**From:** David Henderson <david.henderson@mercergov.org>  
**Sent:** Wednesday, July 3, 2019 9:49 AM  
**To:** Larz Hitchcock  
**Subject:** RE: Kyle Griffith Deck Permit

**From:** Larz Hitchcock <Larz.Hitchcock@jacksonmain.com>  
**Sent:** Wednesday, July 3, 2019 8:11 AM  
**To:** David Henderson <david.henderson@mercergov.org>  
**Subject:** RE: Kyle Griffith Deck Permit

At this time the application is deemed to be incomplete as it is missing the following information. **Please upload all documents per the Mie plan process**, clarifying the proposed scope of the project. Once the application is deemed to be complete, the project will be routed as express review for Civil, Tree, Building and Planning staff approval.

A1

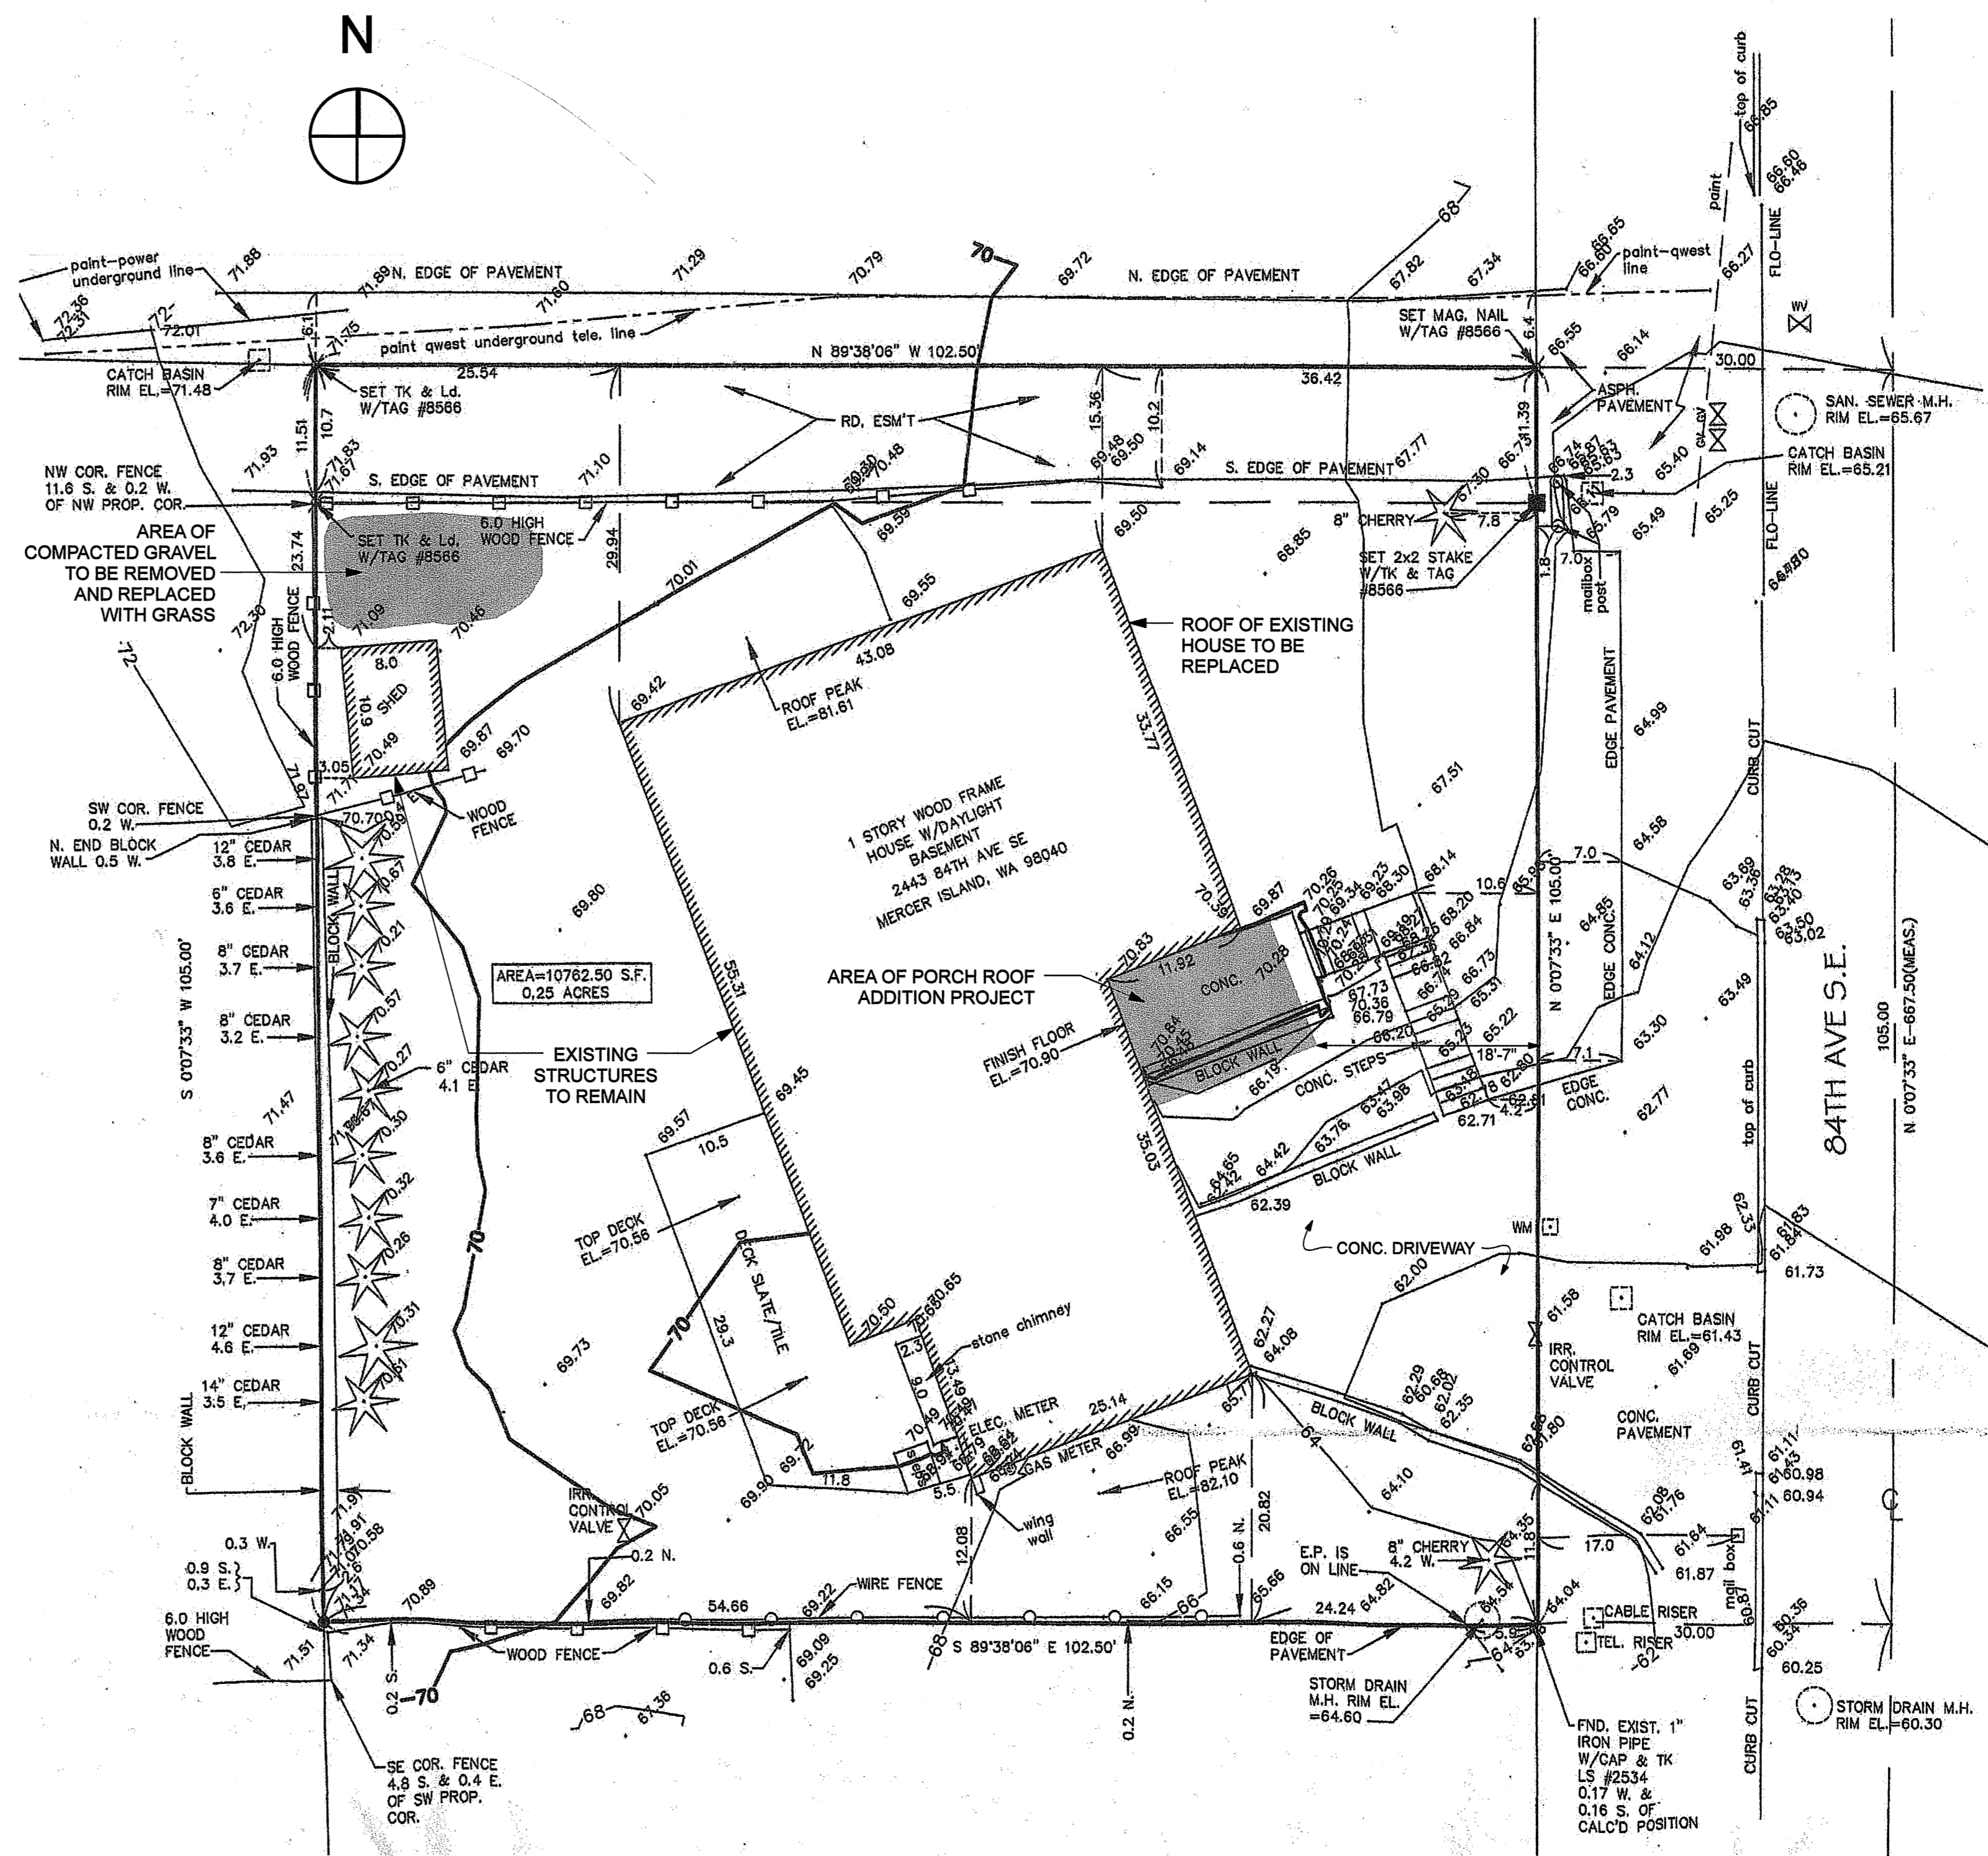
The sheet A1 site plan states "Replace roof on entire residence". This needs greater clarification of the full scope proposed. Is it just the roof covering?

As noted in the side bar, this sheet is for reference only also note it is dated 07/11/2011.

The purpose of including this sheet is the topographical information as required by the city.

We have included a much large "FOR REFERENCE ONLY" across the top to make it more noticeable.

EXISTING SITE PLAN
 PROJECT NORTH TRUE NORTH
 3/16" = 1'-0"

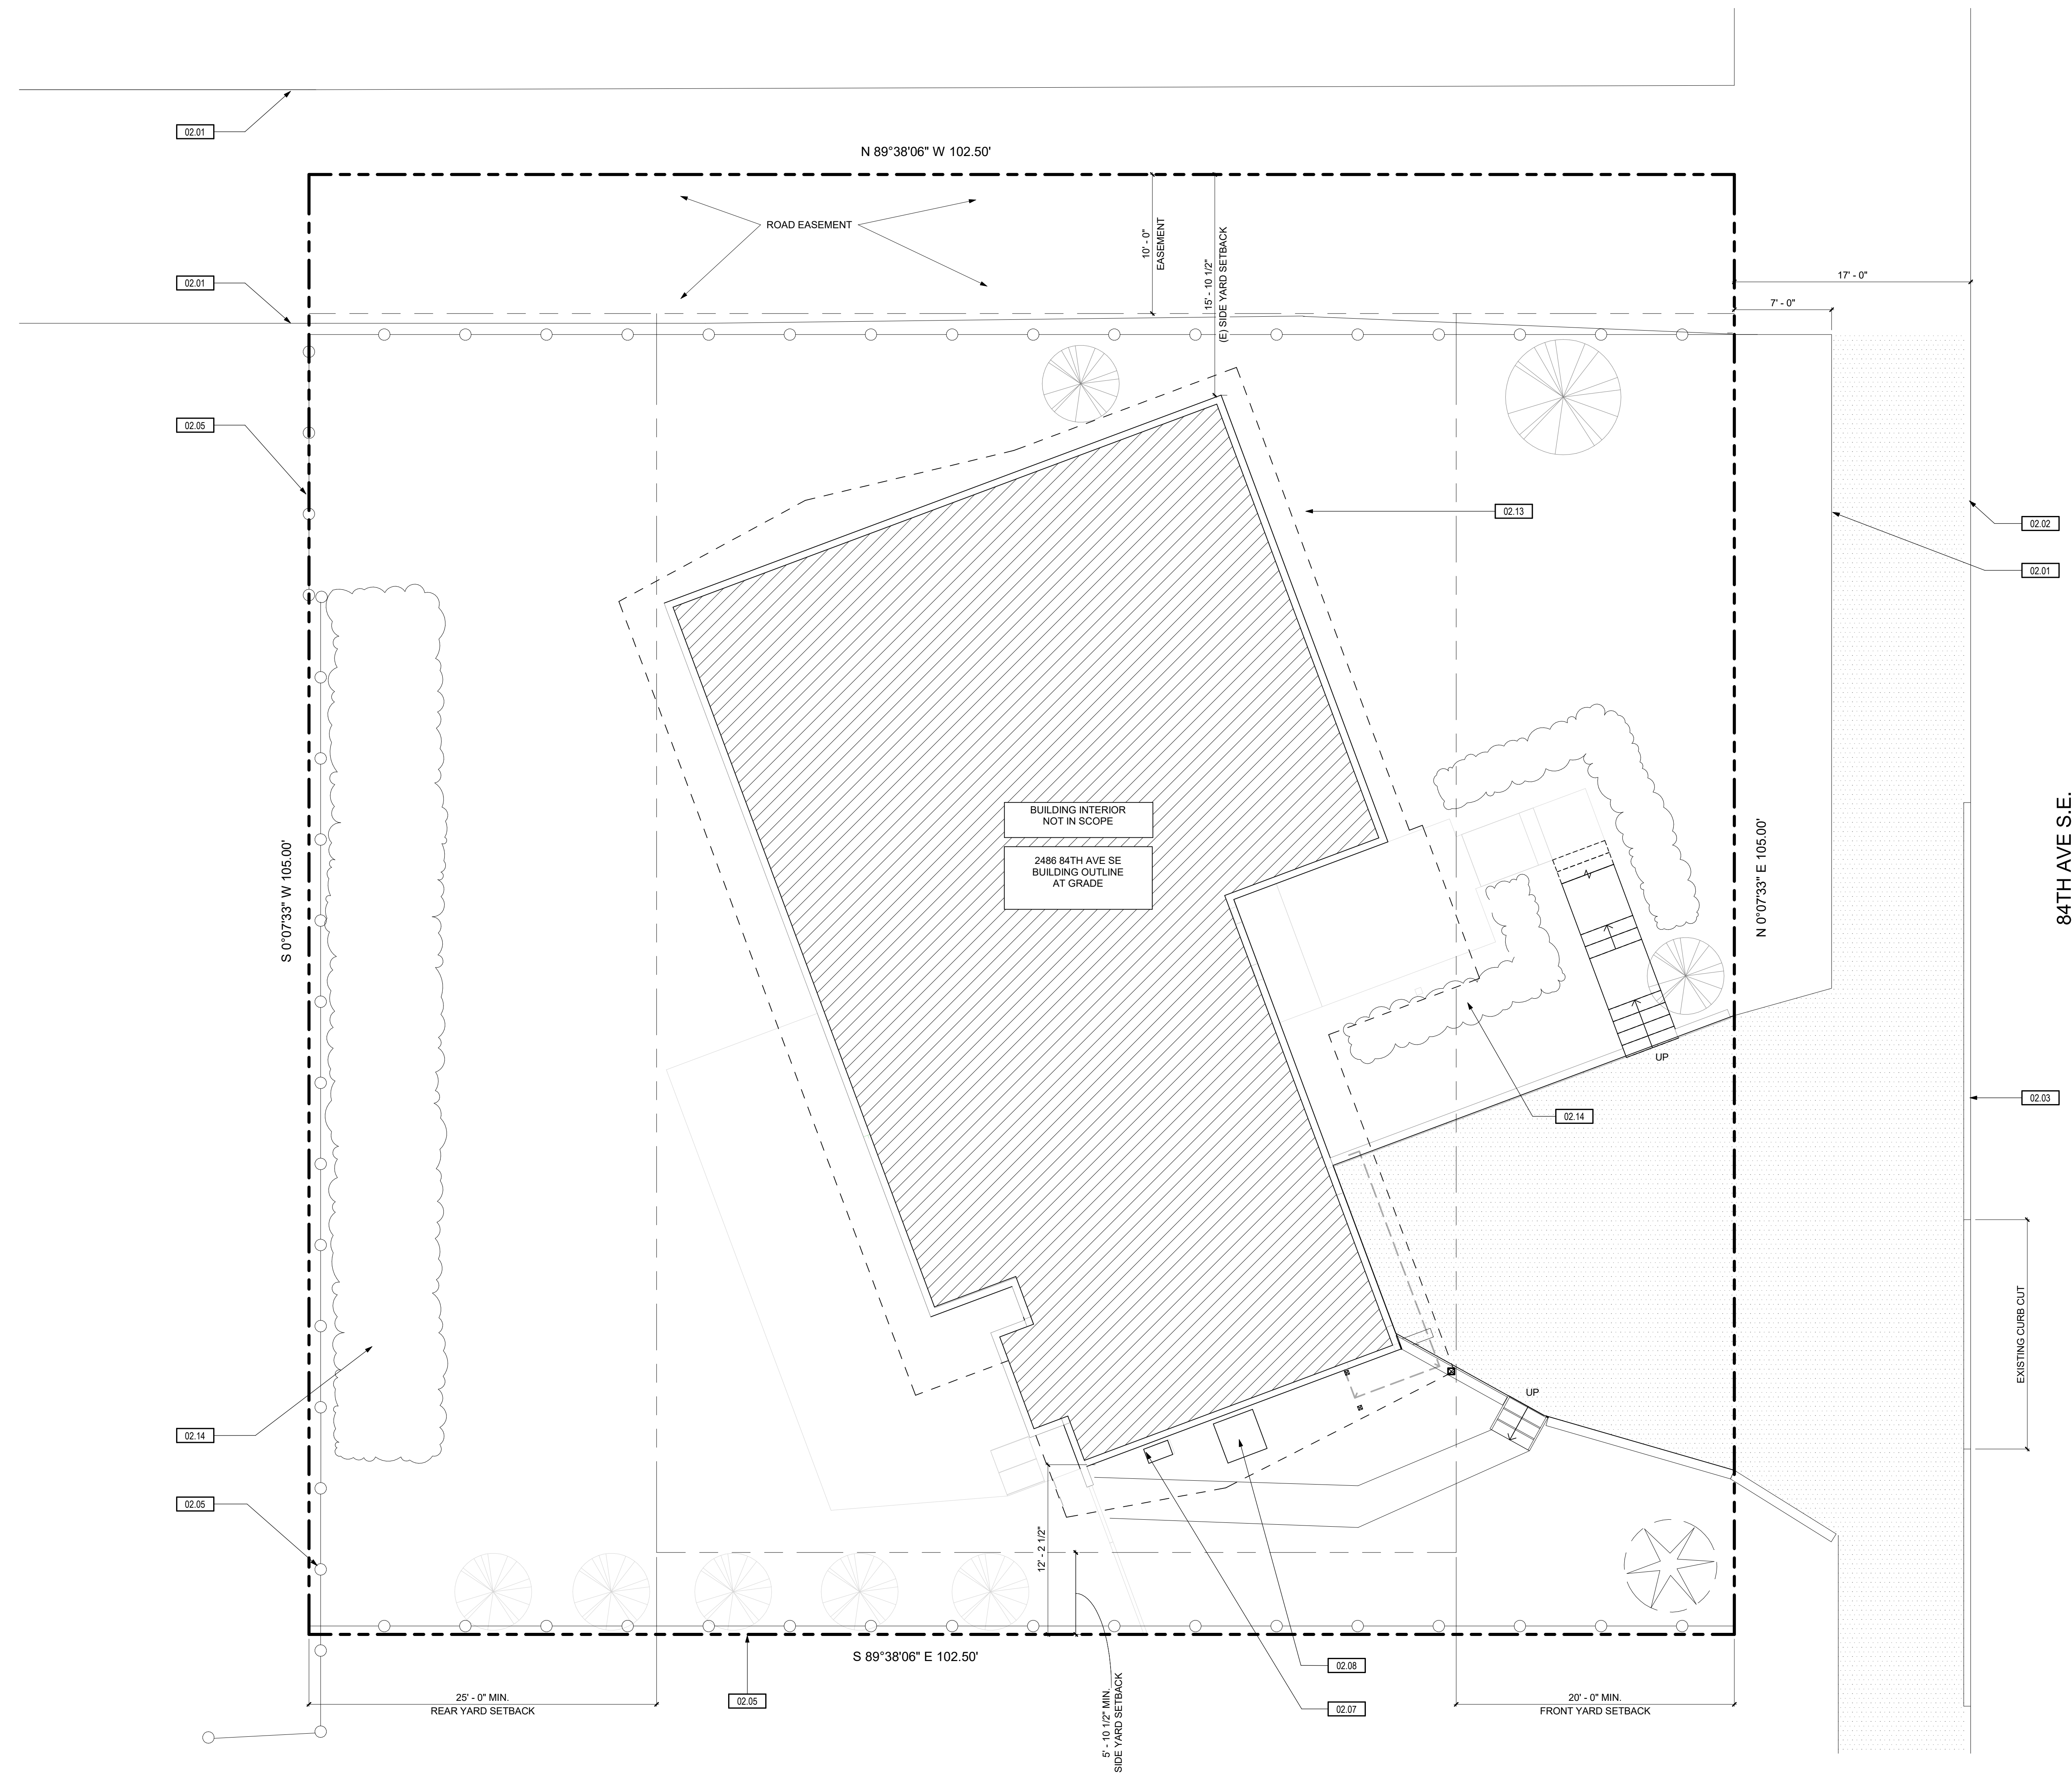
The project includes a new rear covered porch that is potentially decreasing the side yard setback and the site plan submitted is not to scale.

As seen on A0.01 no part of the existing roof is in the setback.
